From: Roger Spencer
Sent: 17 August 2017 18:15
To: Planning.Responses
Subject: RE: Planning Consultation on: LU/243/17/PL

APPLICATION LU/243/17/PL

Site Address: 56-57 Pier Road Littlehampton BN17 5LP

Description of Conversion & minor extension of existing restaurant & five

Drawing Title
Proposed Drawing
Lower and Upper Ground Floor Plans
1/100 @ A3

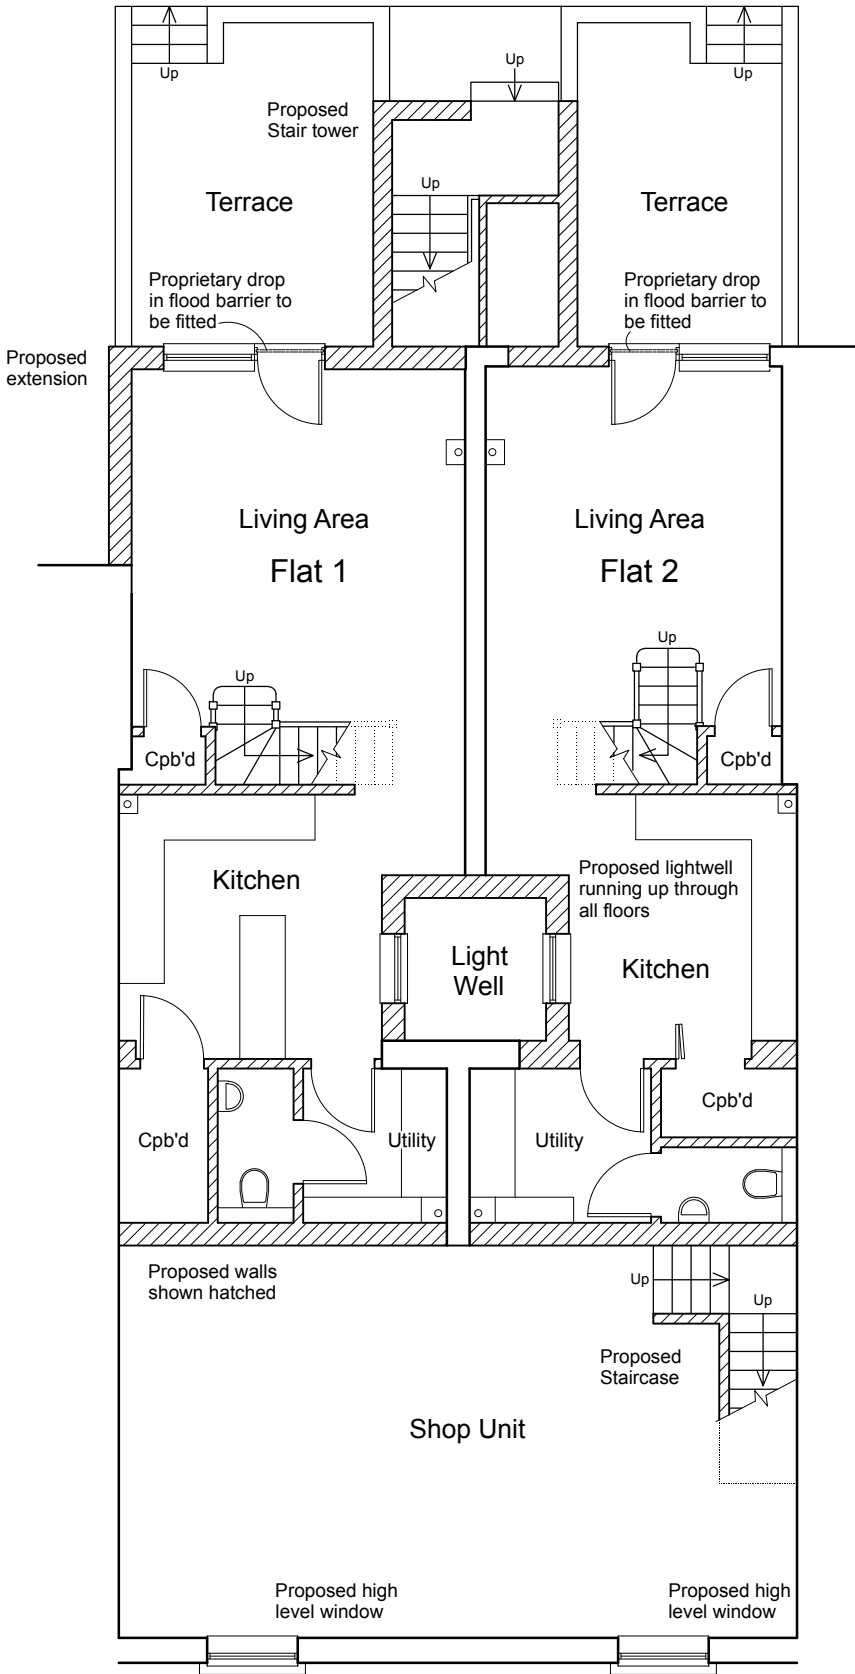
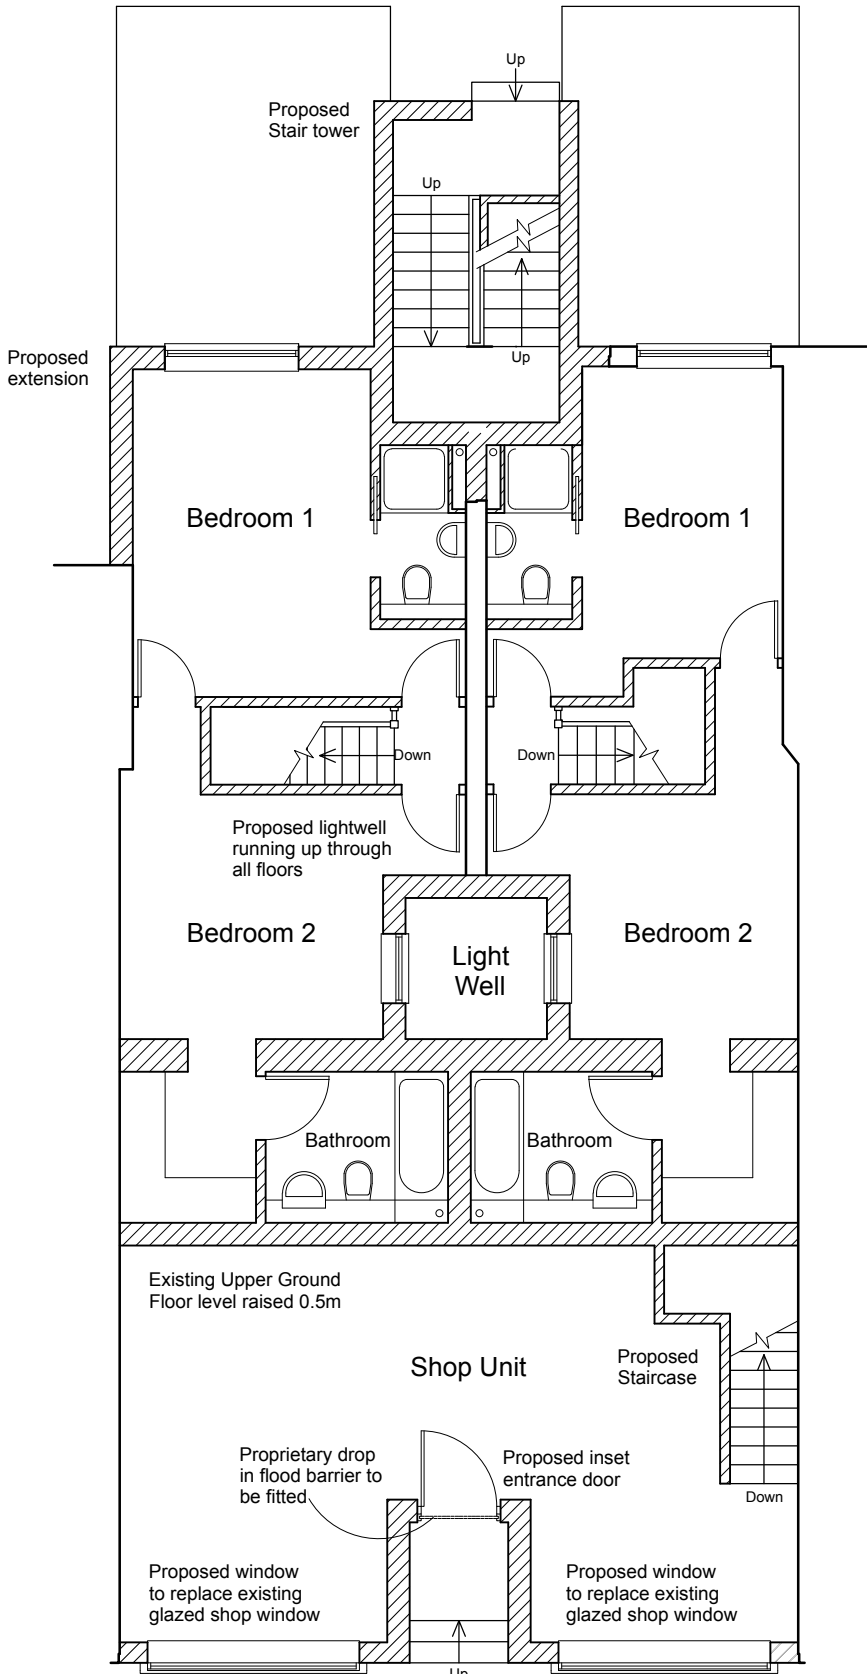
I note that the proposal includes installing lights, at and below footpath level, into the 'lower ground floor' which on one drawing is described as a basement and/or store – there may also be headroom issues here, as I cannot see what the existing headroom is from an existing section – is the floor of the 'lower ground floor' staying as existing basement or might there be a wish to extend down to gain headroom, in which care will need to be taken in carrying this out.
